BHS Bedfordshire comments on Applicant's responses (REP1-055 and REP1-056) to our Relevant Representation (RR 1253)

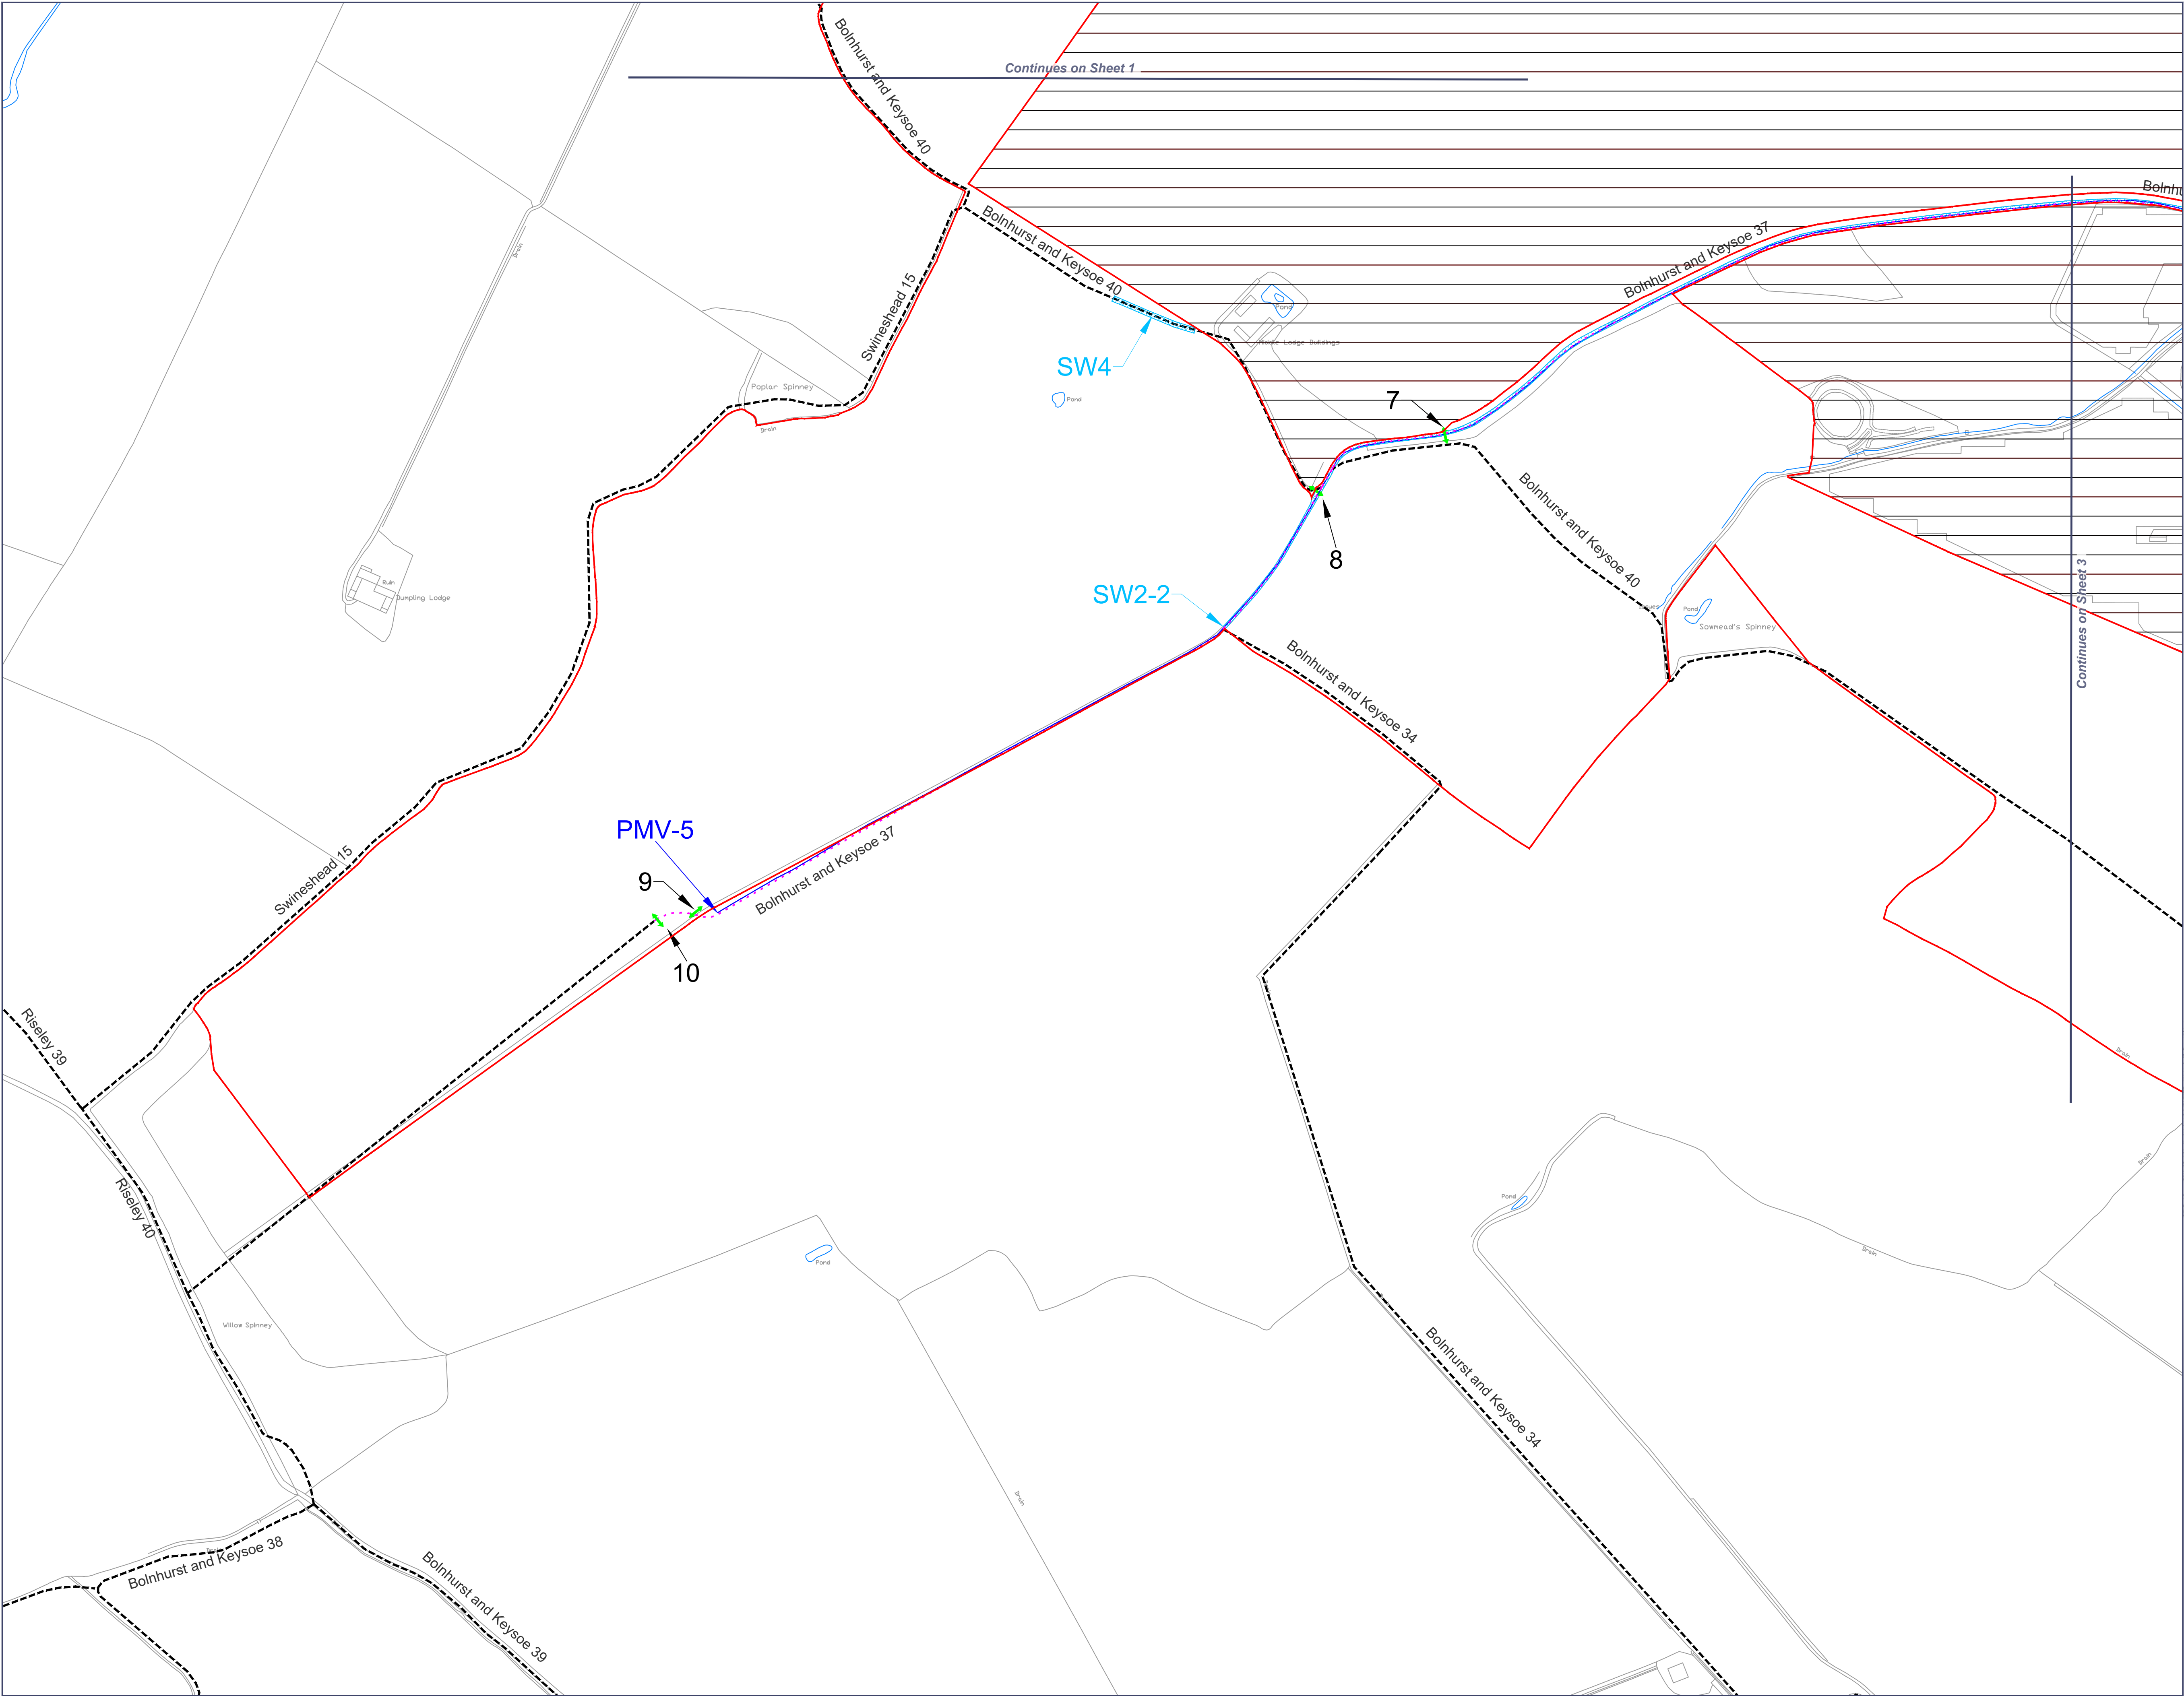
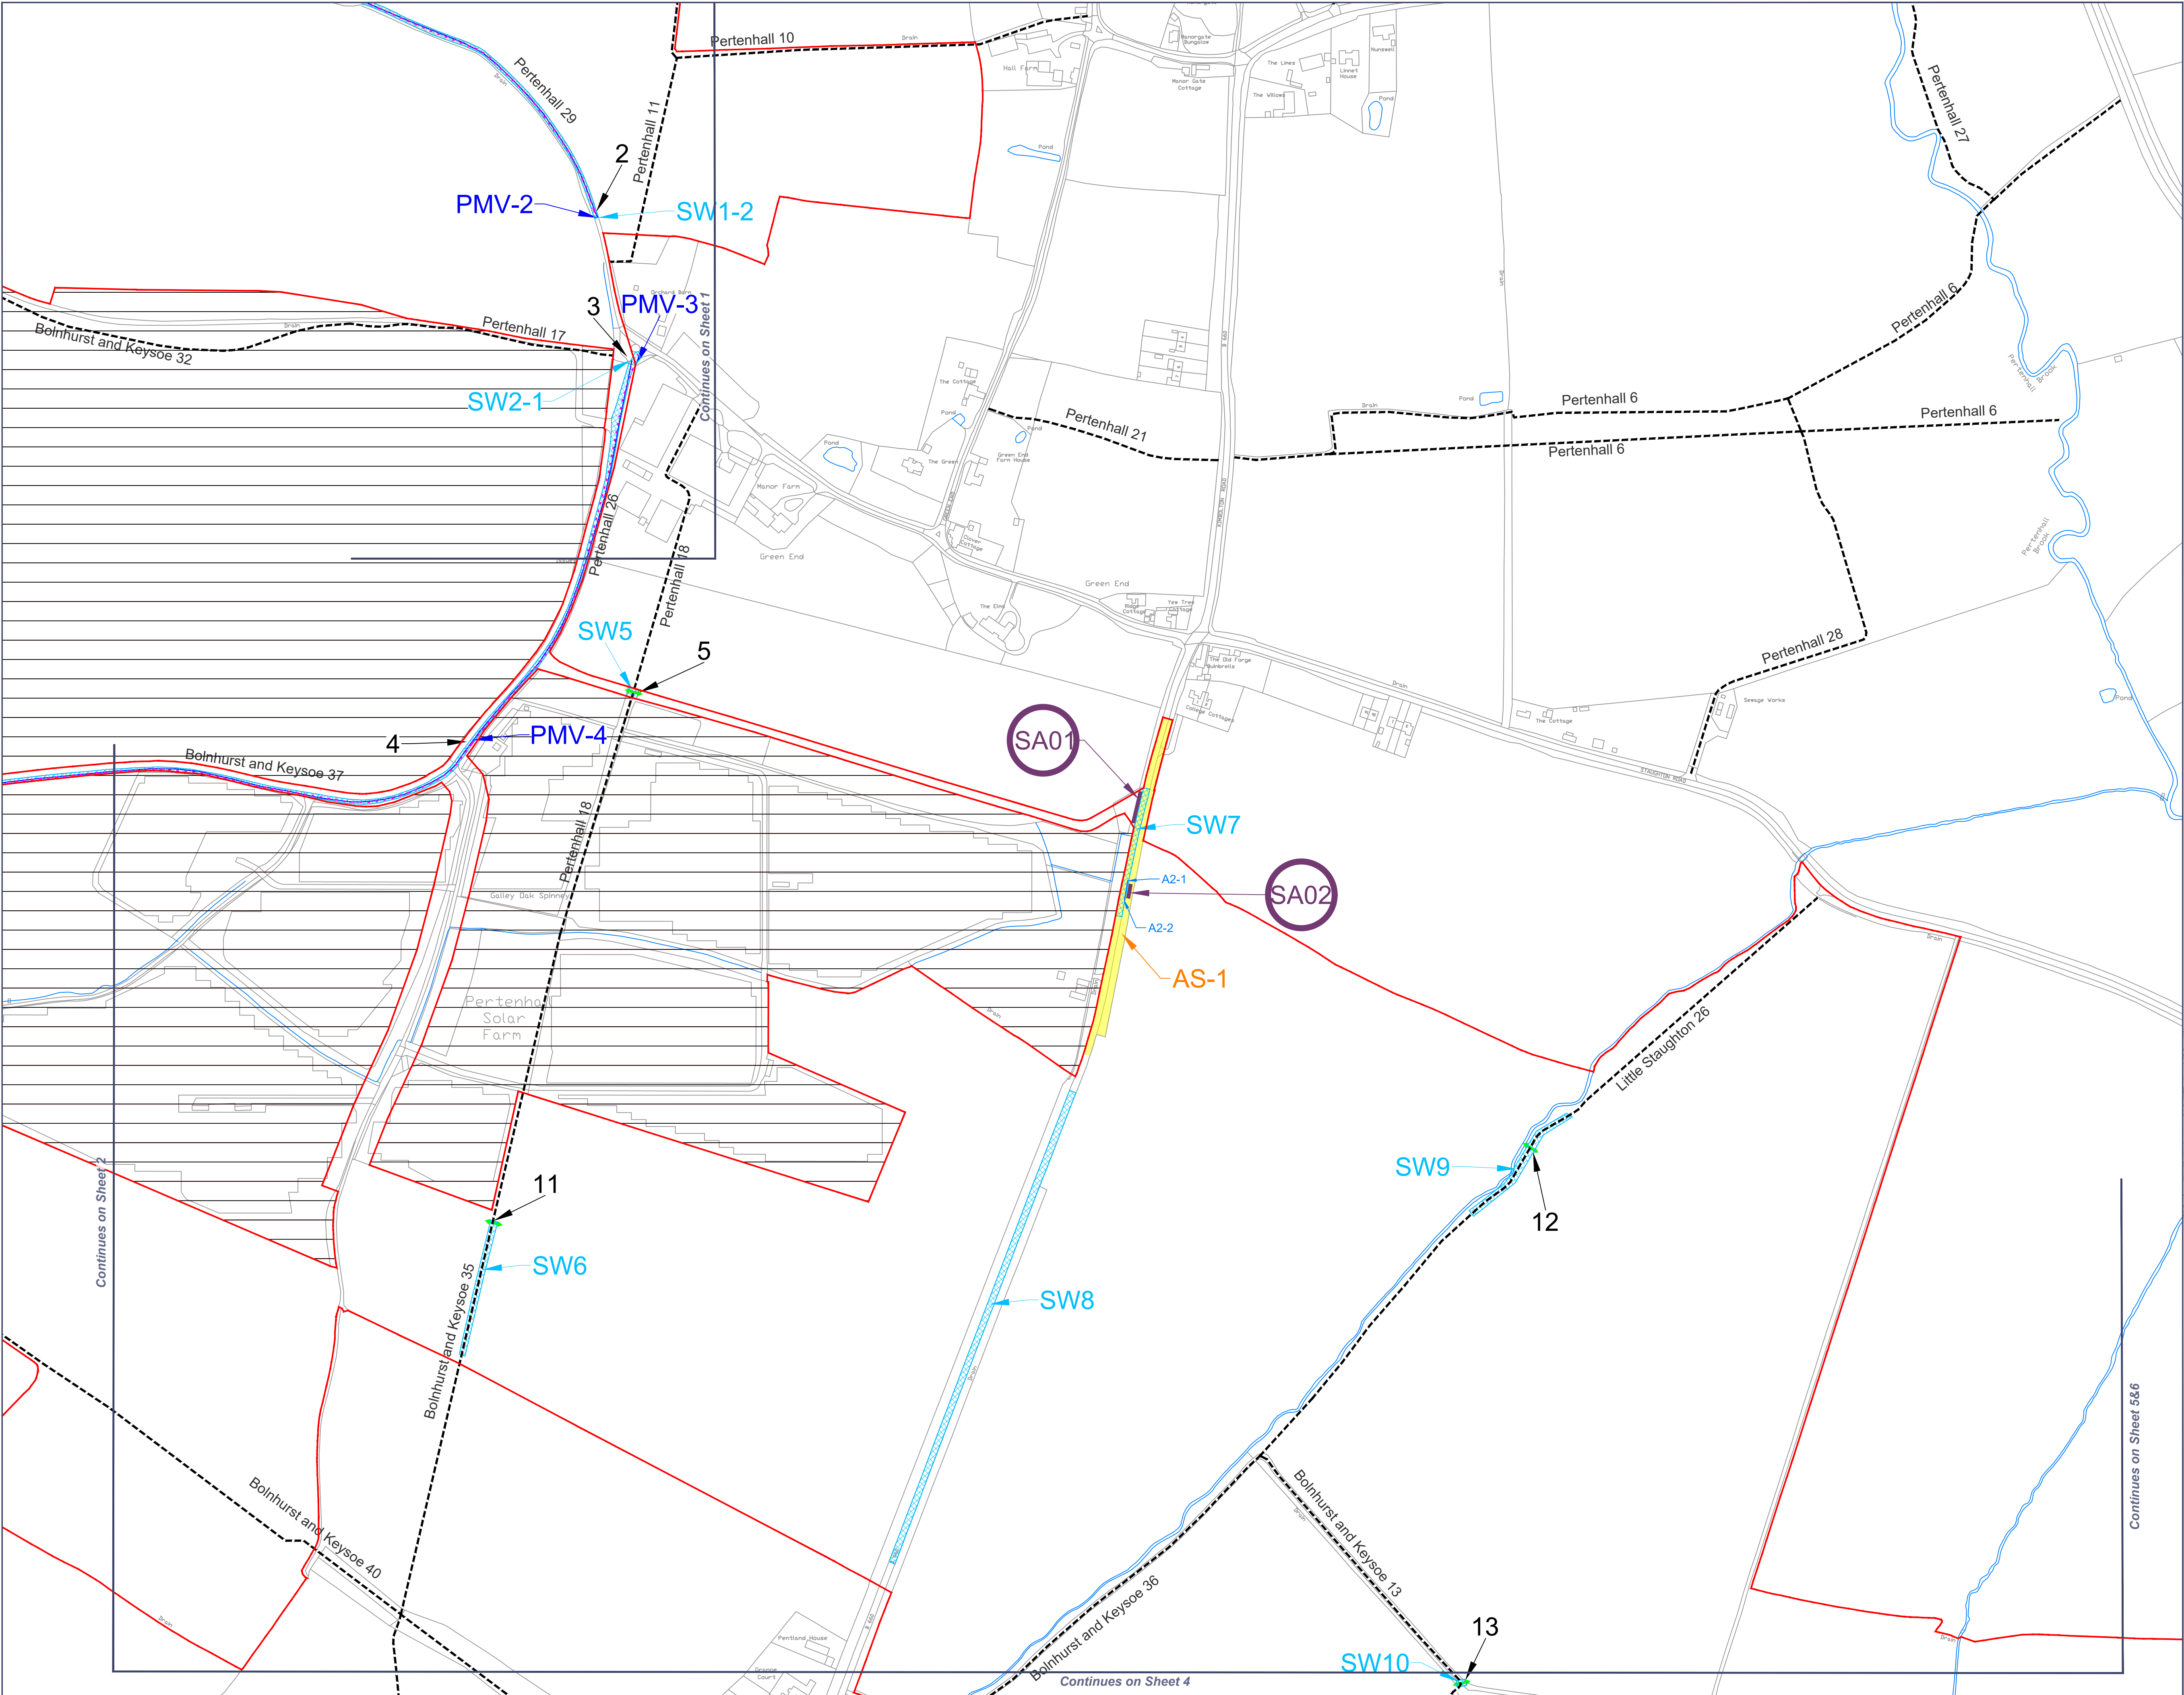
- The noise and vibration from the installation of the arrays alongside the bridleway
- The cable laying along 1,340m between SW2-1 and SW2-2 (on sheets 1 and 2 of the street works plan)

Regarding the cabling, paragraph 6.8.7 states that

PRoW users would be required to follow a localised diversion (in the order of a few metres either side of the existing PRoW alignment) around the works site.

A 'few metres' is just not enough space for equestrians. Of course, if the construction activity has genuinely been ceased as the oCEMP envisages than that might be adequate BUT as explained above I do not consider that proposal to be credible – a horse and rider on BW37 will not, in my view, be noted in time for the stop order to be conveyed to the workmen laying the cable to be directed to stop.

The Society remains of the view that the only safe option here is to provide an alternative diversion further away from the construction traffic and activity. This is within the gift of one of the landowners who is benefitting from this development. To continue with the current proposals is to close the bridleway to equestrian users during construction hours, without acknowledging that this is the case.
